Neighbours of Little Lane

Reference: Planning application No: 3/2024/0096

We are writing to express our concerns regarding the proposal for a replacement boundary fence to be erected at the back of the gardens, which will impact many homes and our quality of life.

DRAWING TITLE:
Site Plan with Proposed Fencing

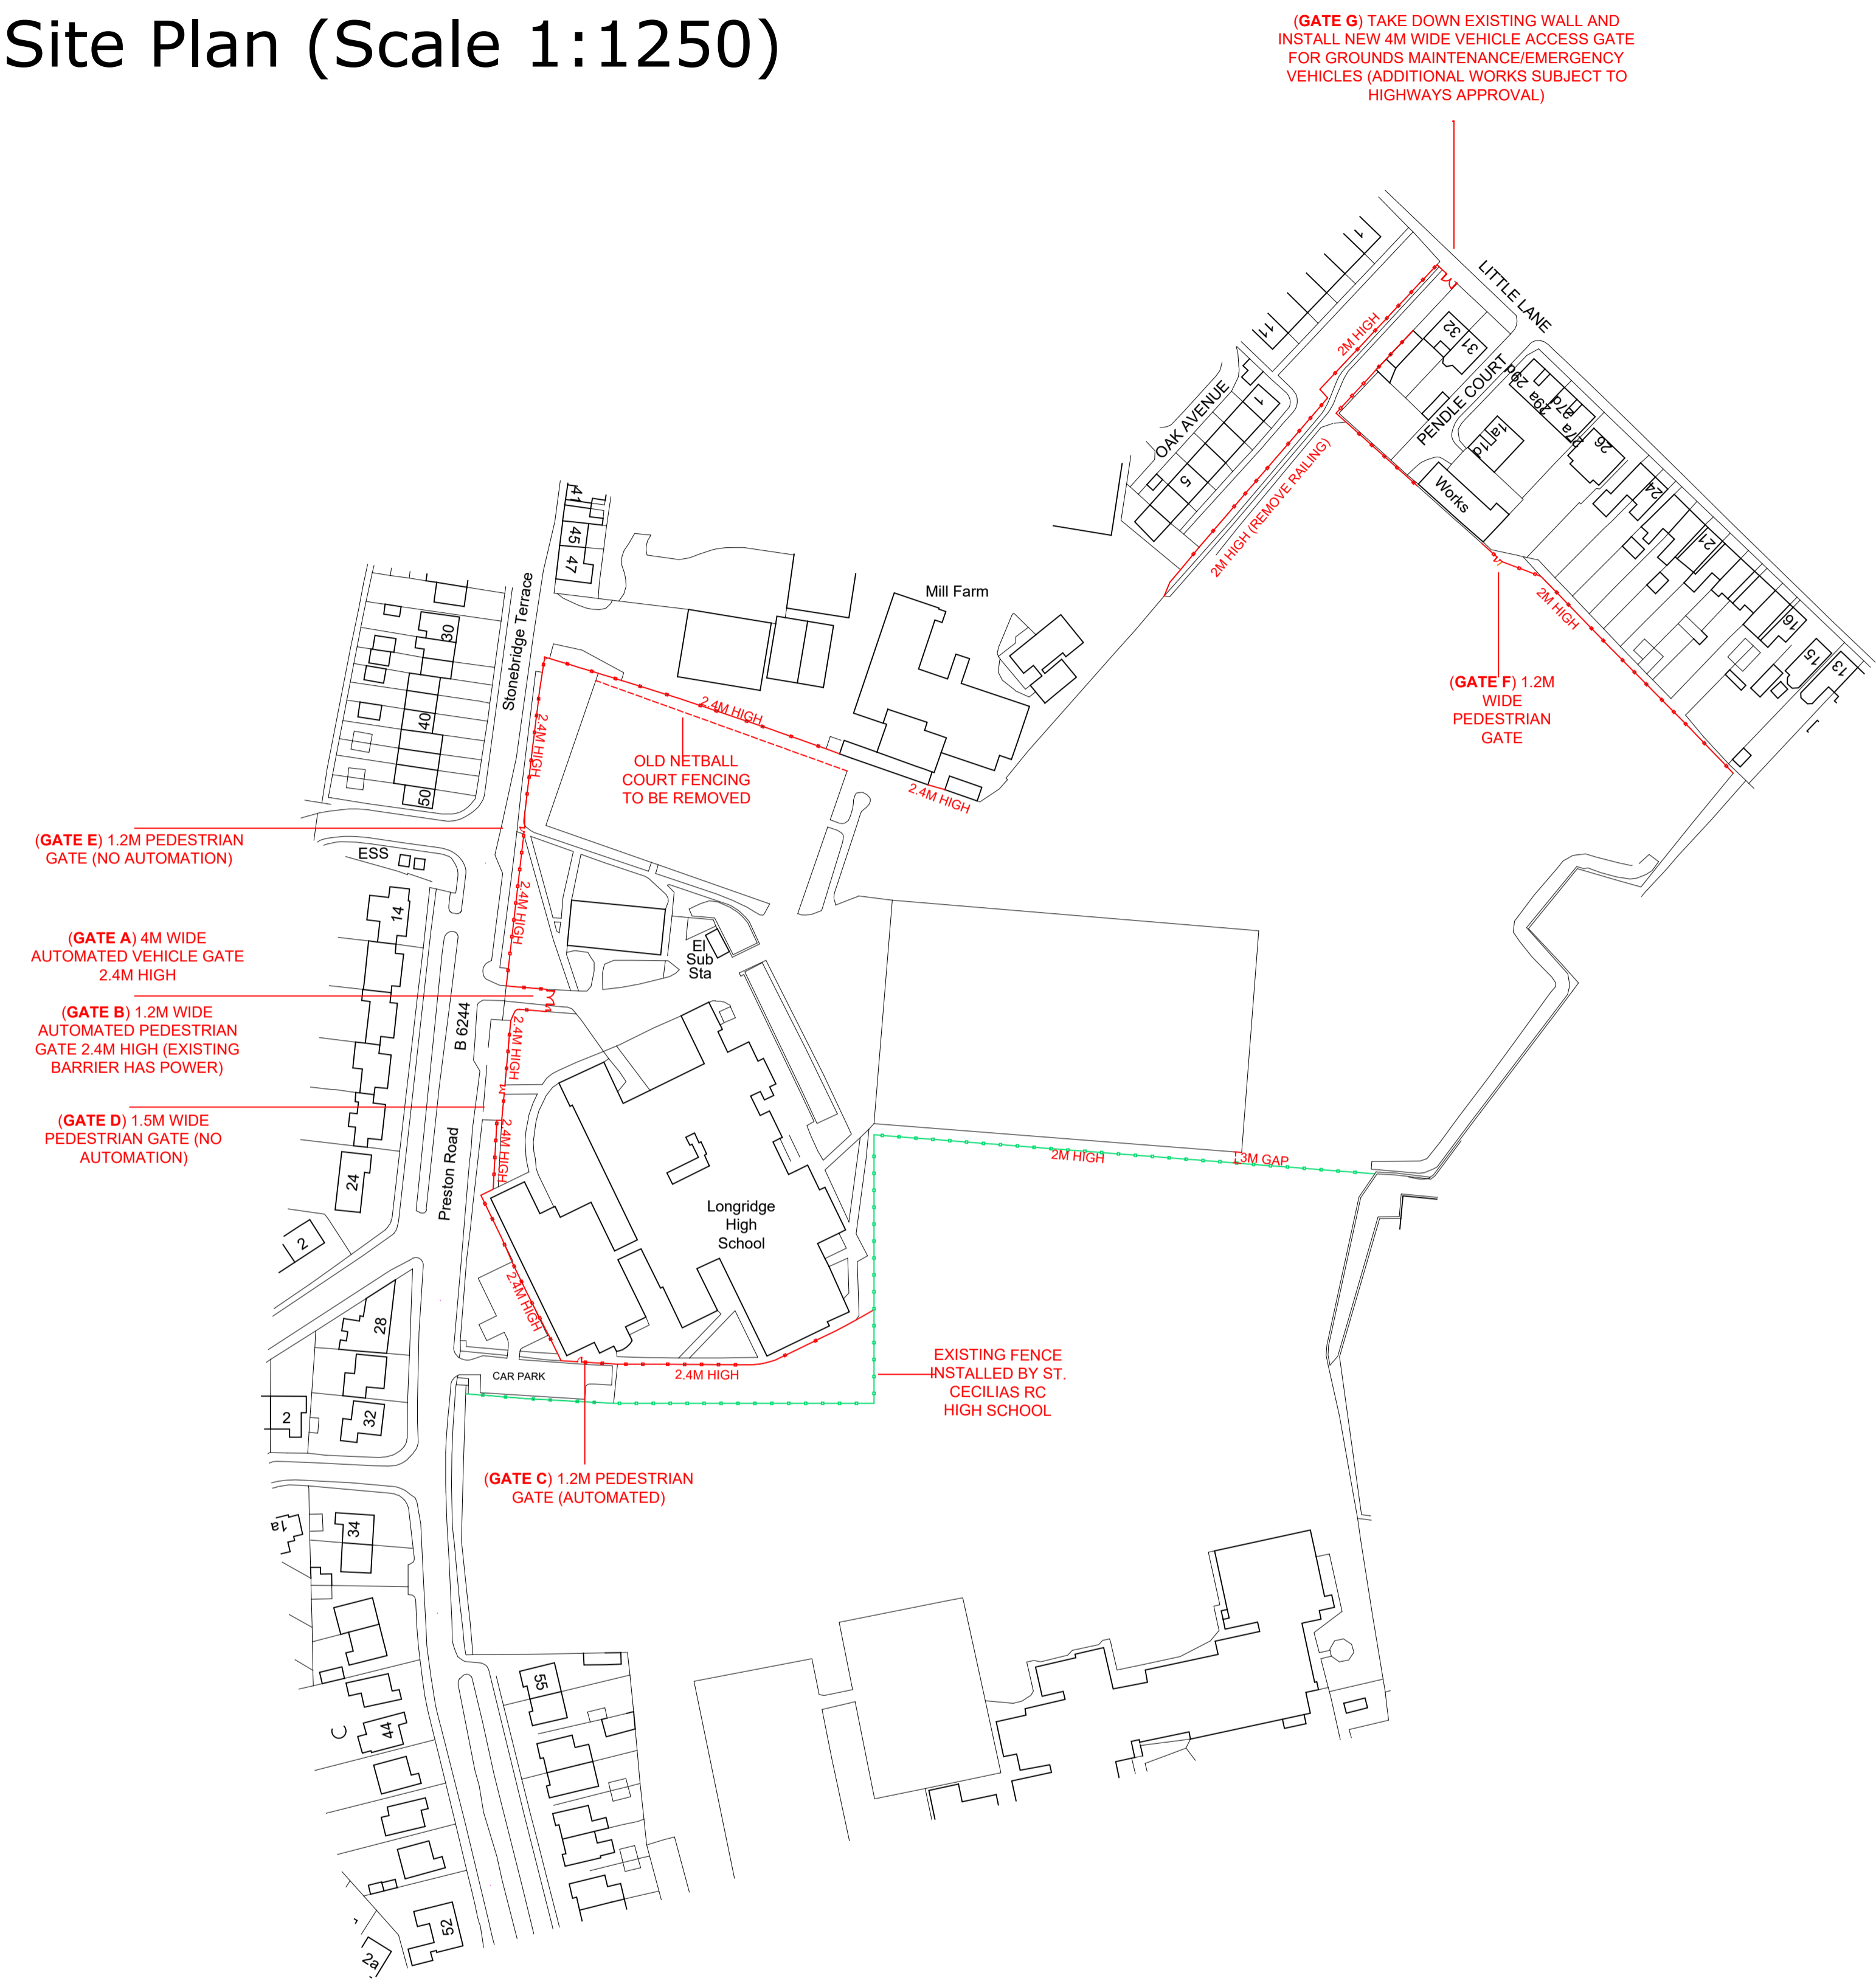
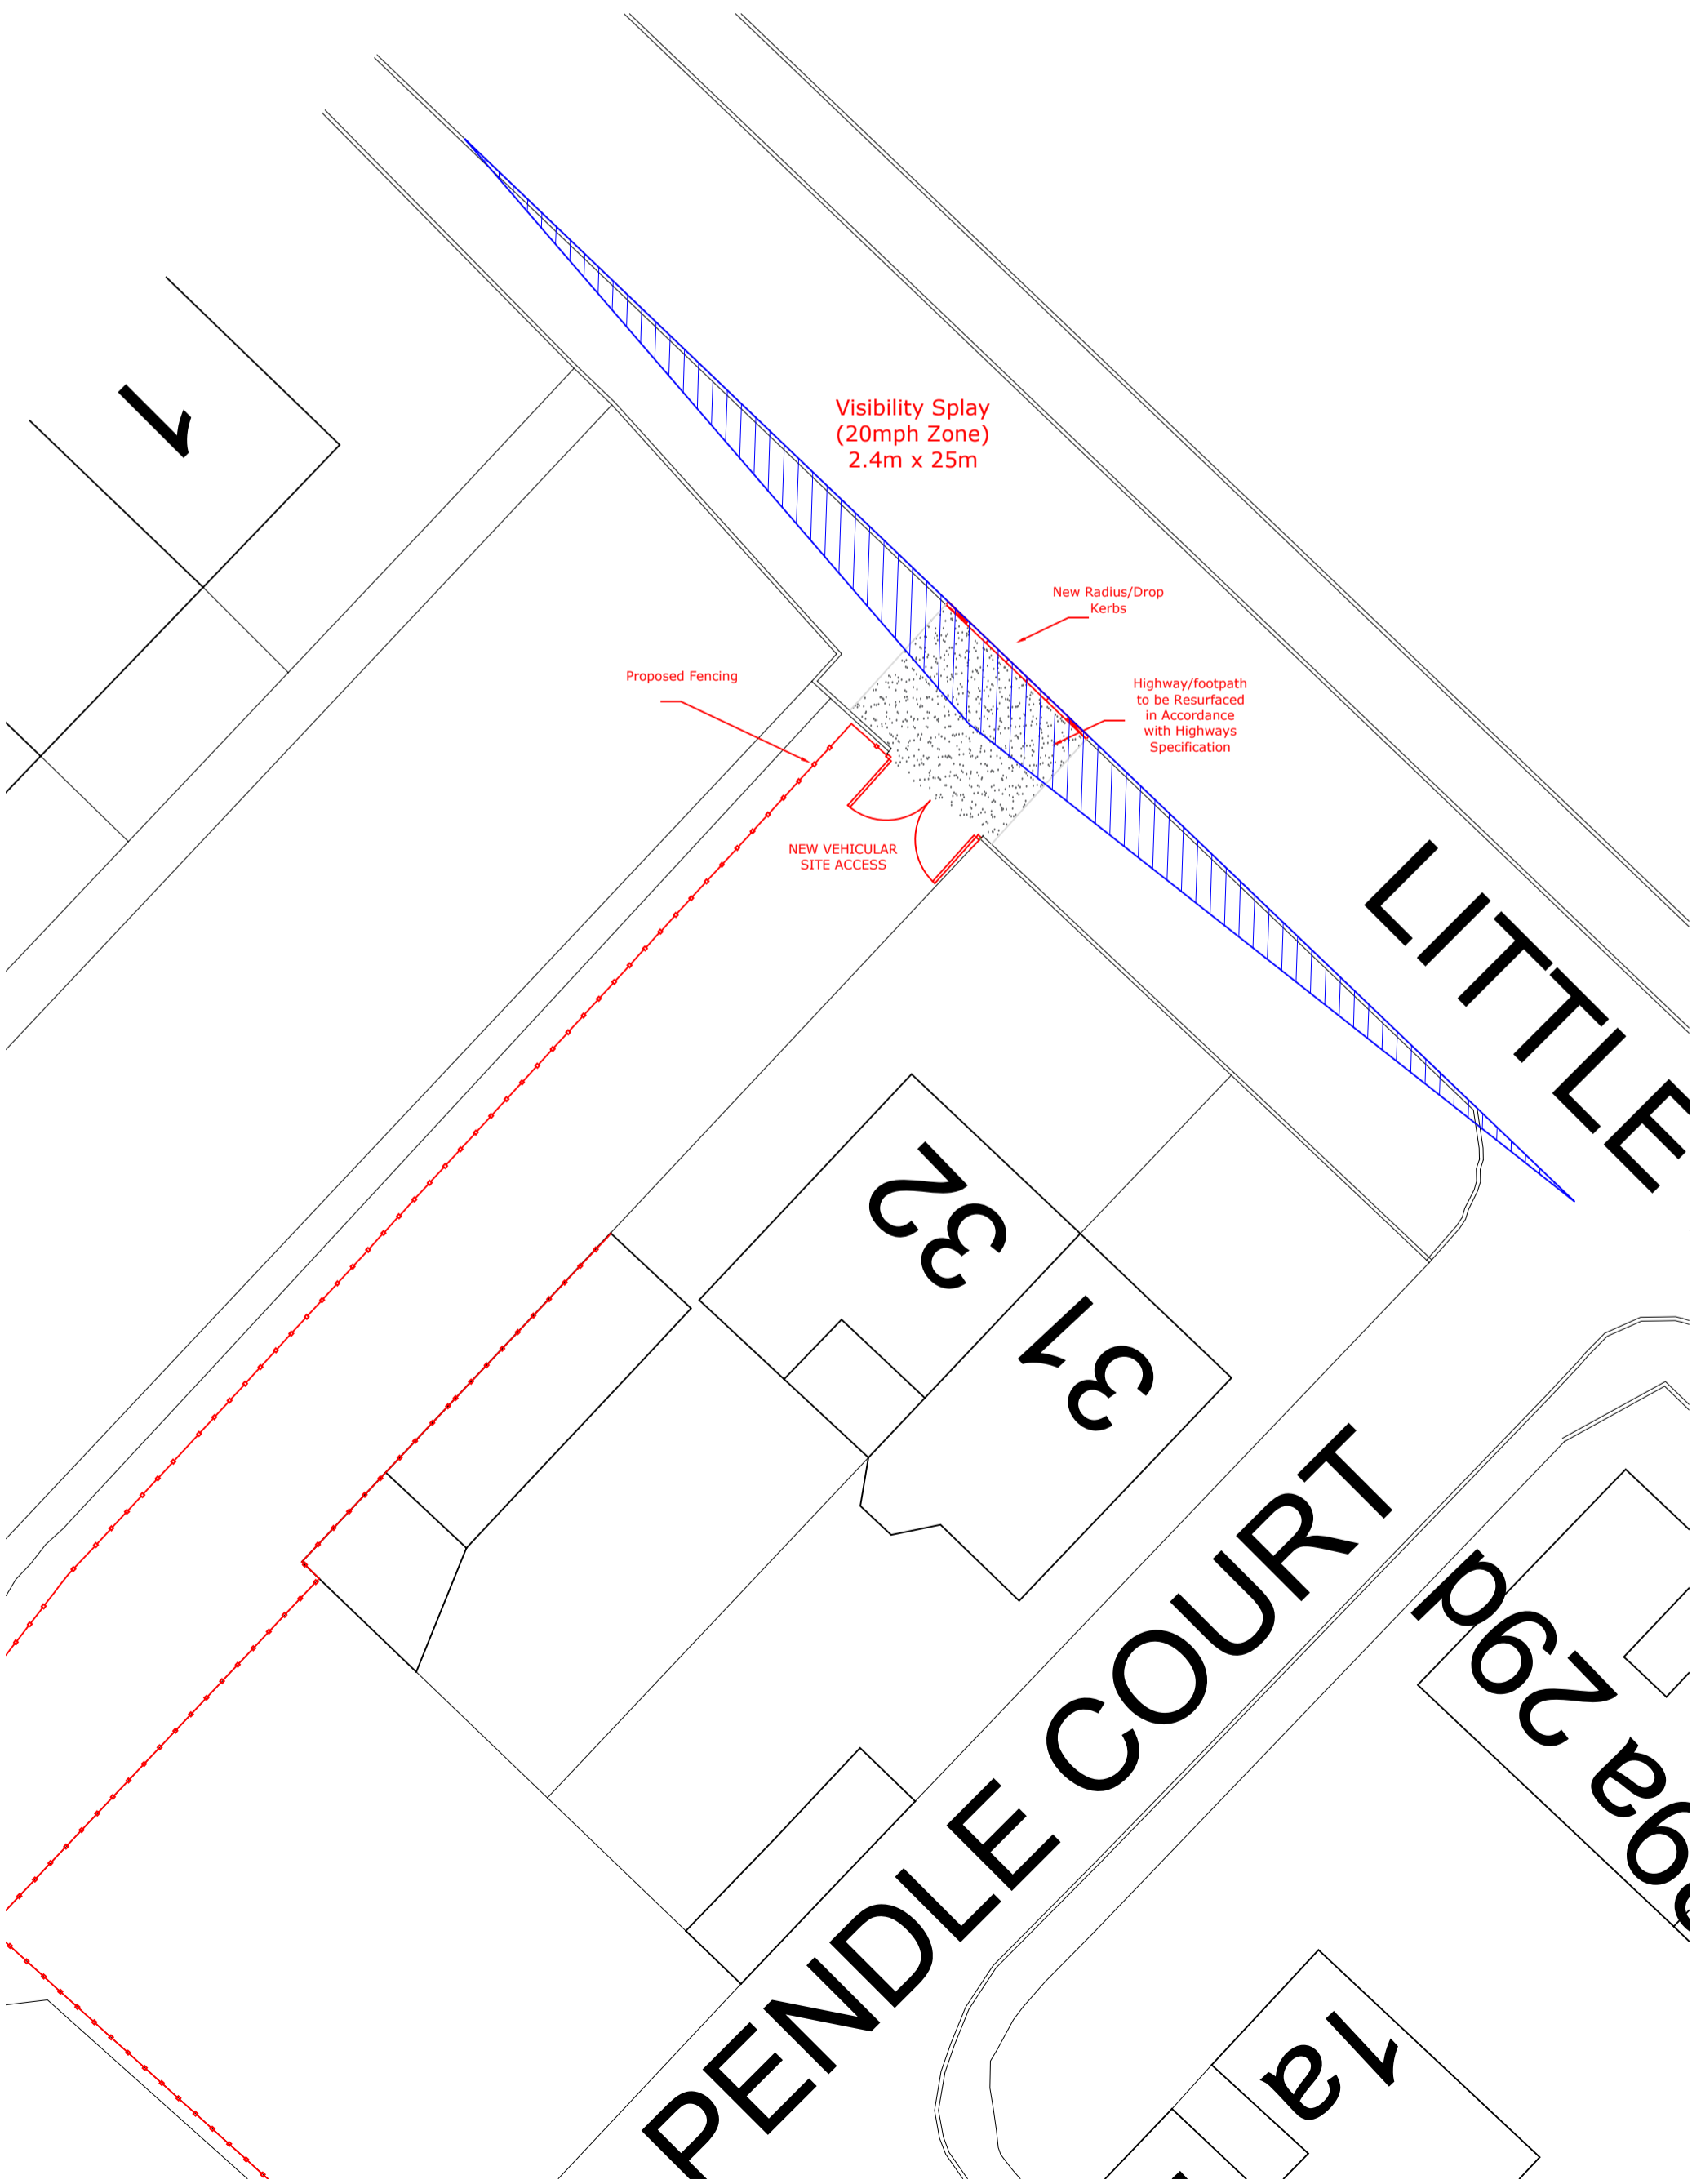
One critical aspect that the proposal fails to clarify is the distance that will separate the new fence from our existing fences and thus the boundary lines. This information is crucial for us to understand the implications for our properties. Additionally, we are concerned about the potential impact on vehicle access.
